**Exhibition of Preferred Project Report for Rozelle Village / Balmain Leagues Club (MP11\_0015)**

Thank you for the opportunity to provide comment on the project application for Rozelle Village / Balmain Leagues Club. The State Transit Authority operates a large number of bus services along the Victoria Road and Darling Street frontage's of the development. These services, as suggested in the traffic modeling report will be impacted by the proposed development.

Figure 2 – Modelled Site Access Arrangements

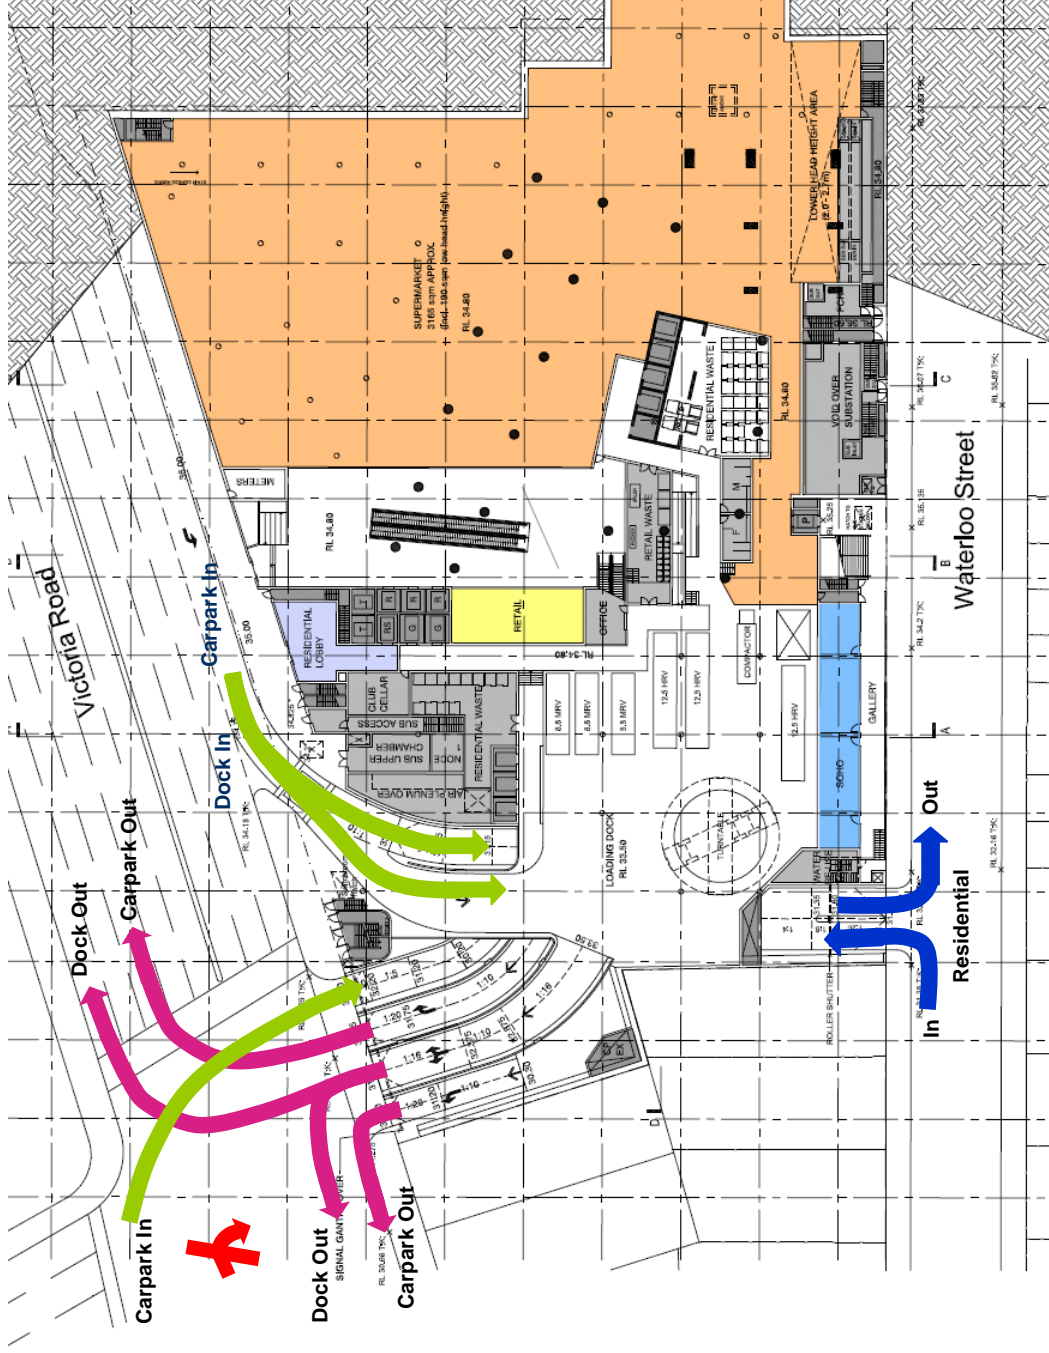
It is unclear how the porte le cohere and taxi drop off / pick up is suppose to function, given the small area. The facility needs to be made larger in order for it to be practicable for its application and/or otherwise removed from the plans.

Figure 11 – Existing Bus Stop Locations

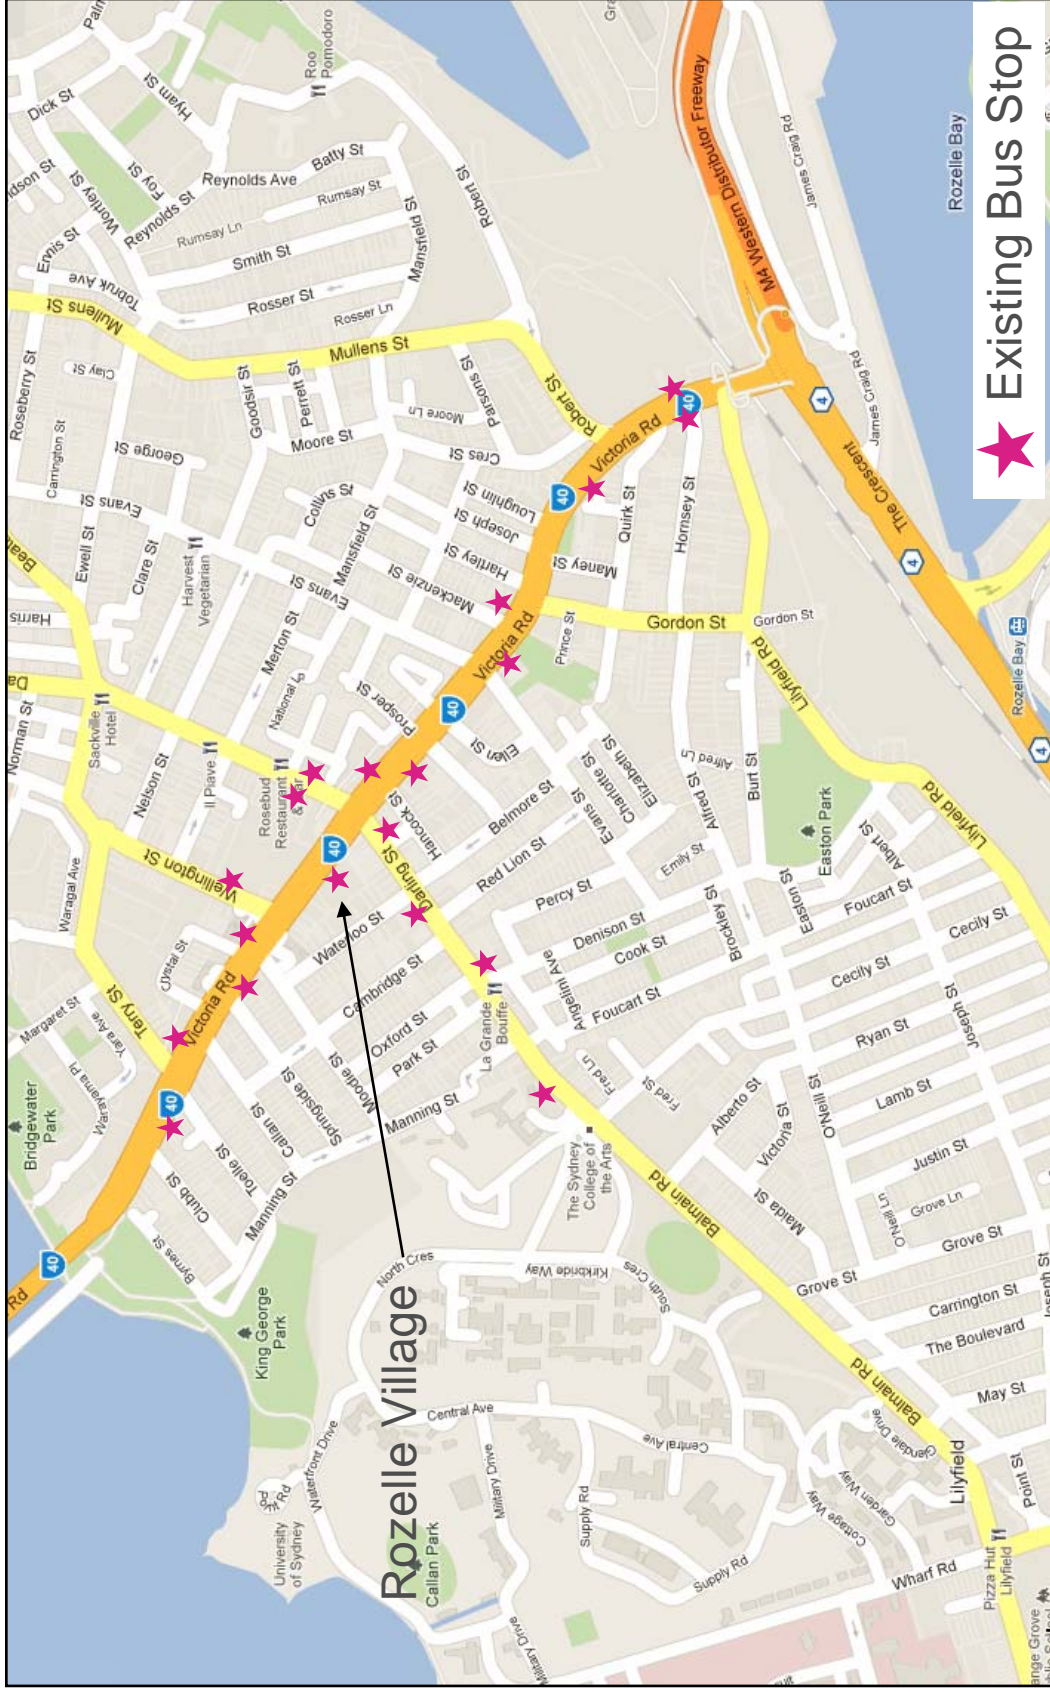
All bus stops along Victoria Road and Darling Street in the immediate area of the development should be upgraded to comply with DDA standards. The inclusion of real time information should also be part of the upgrade.

The relocation of the bus stop on the southern side of Victoria Road, east of Darling Street should be further considered in consultation with Roads and Maritime Services and State Transit Authority.
